# The Sizewell C Project

## 9.3 SZC Co.'s responses to the Examining Authority's further questions on the relationship between dDCO and the ES

May 2021

Revision: 1.0  
Applicable Regulation: Regulation 5(2)(o)  
PINS Reference Number: EN010012

DRAWING TITLE:
 SPORTS FACILITIES
 RIGHTS OF WAY PLANS - SHEET 11 OF 28

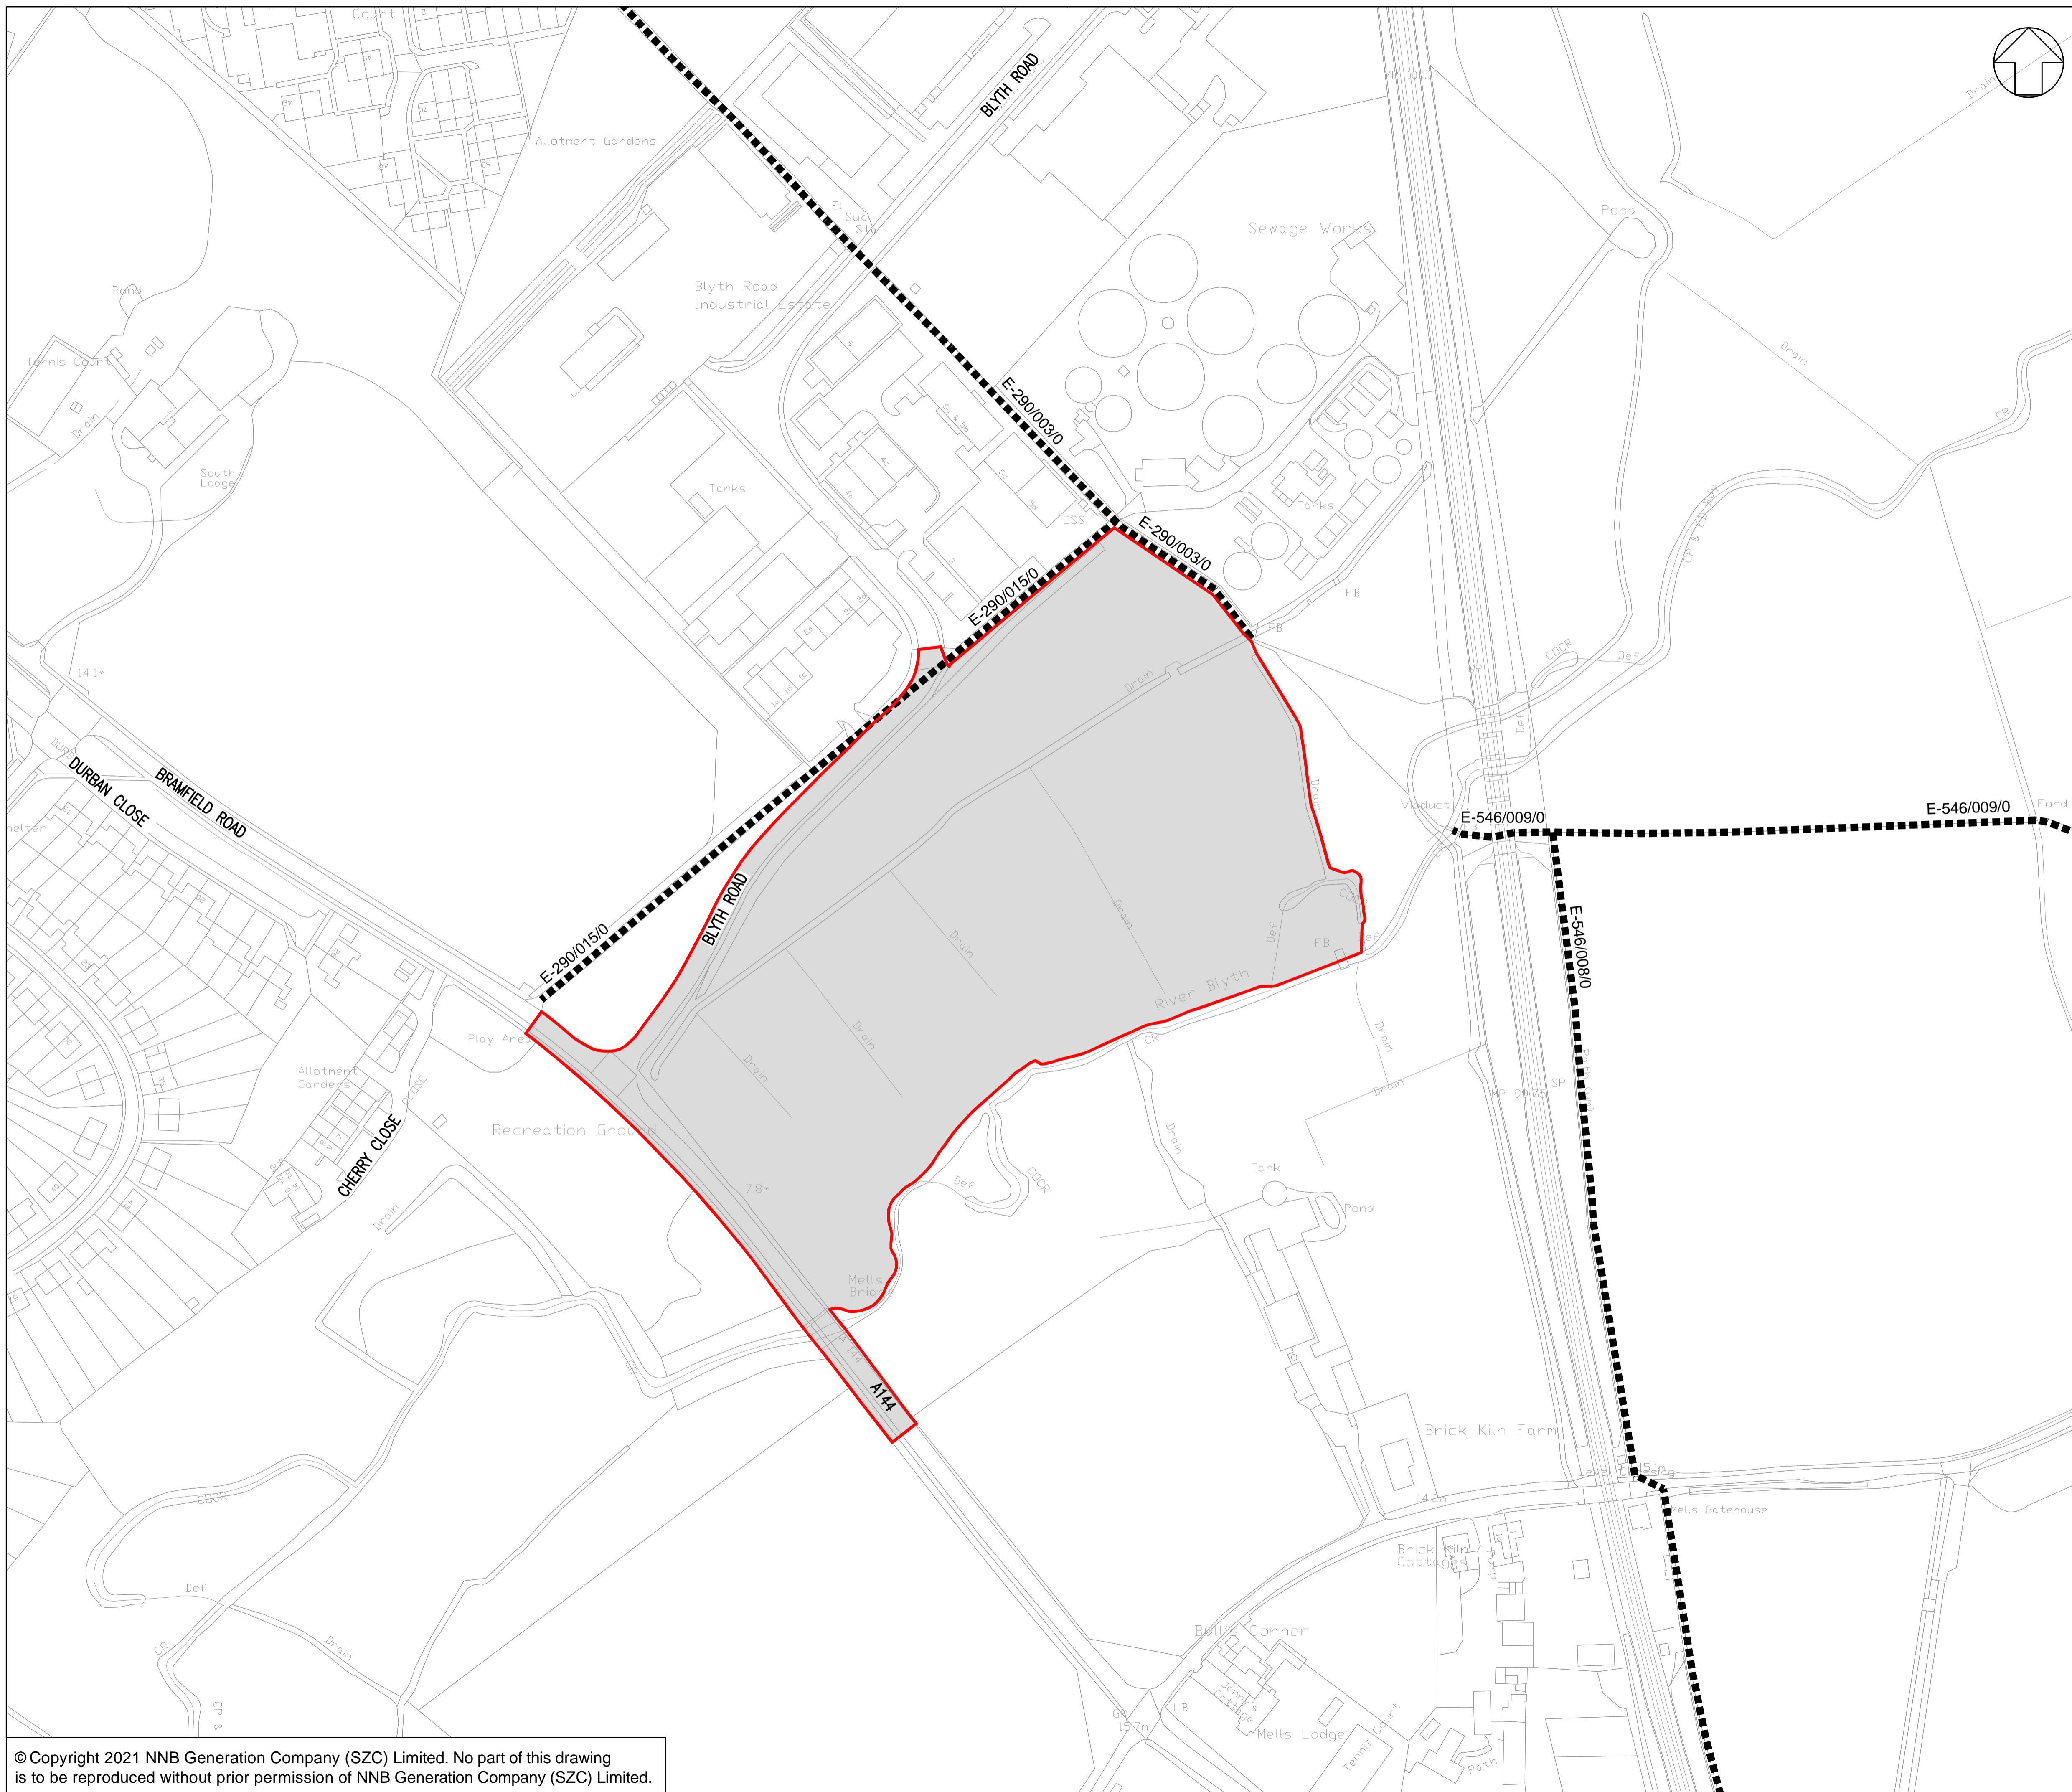
Q2			<p><b>Aide Valley Academy Lotion</b></p> <p>The draft DCO describes the Sports Facilities at Work No. 5 as "Landscape works including open space, sports facilities and associated structures and plant".</p> <p>The location of the above works is shown on sheet no. 11 of the Works Plans. However, this does not appear to correspond with either of the descriptions in the ES Vol 2 Ch. 2 (APR 188) Description of permanent development para 2.8.1 or ES Vol 2 Ch. 3 (APR 184) Description of Construction para 3.4.222.</p> <p>Please clarify what has been assessed in the ES and make clear where the details of the floodlights, illumination plans, and acoustic barriers can be found.</p>	<p>The Applicant will update the draft DCO to more closely align Work No 5 with the description of development in the ES. ES Volume 2, Chapter 8 (noise and vibration) assumes a permanent 2m acoustic fence at para. 11.6.178 (i.e. referring to 1.18 in the ExA notes that 1.18 is part of the Material Change required on which a decision has yet been made. The floodlights and screens are an assessment of the pitch as it would not result in significant adverse effects.</p> <p>The Applicant will be proposing an additional Requirement to submit reserved matters for details of the layout, scale and external appearance of the buildings and landscape works contained in Work No 5. This additional Requirement will be included in the updated draft DCO submitted on 11 January 2021.</p>	<p>The amendment to the description of Work No. 5 in the DCO versions 3.1A and 3.1B is welcomed as proposed requirement 1.2A in Volume 2, Chapter 13 (landscape and visual) recognises at Appendix 12C that the sports pitch would be illuminated and screens are an assessment of the pitch as it would not result in significant adverse effects.</p> <p>Please will the Applicant:</p> <ol style="list-style-type: none"> <li>(a) clarify how Work No 5 in its original and amended form has been assessed in the ES.</li> <li>(b) explain where the limits in drawing PD017 021-06-02 Pt (which is referred to in proposed requirement 1.2A) have been assessed and regarded as limits (and state where in the Application documents that drawing is to be found).</li> <li>(c) explain the basis on which the floodlighting was assessed out.</li> <li>(d) define the number of lighting columns, specified type of construction e.g. monopole or lattice construction, and the luminosity/level of</li> </ol>	<p>The Applicant commits to reviewing both the descriptions and the assessment accordingly, particularly in relation to lighting and limits as referenced by the ExA. The Applicant will provide an update on this matter by Deadline 1.</p>	<p><b>Noted.</b></p>	<p>The Applicant's review of the descriptions and assessment of Work No. 5 is ongoing. The Applicant will provide a further update on this matter at Deadline 2.</p>
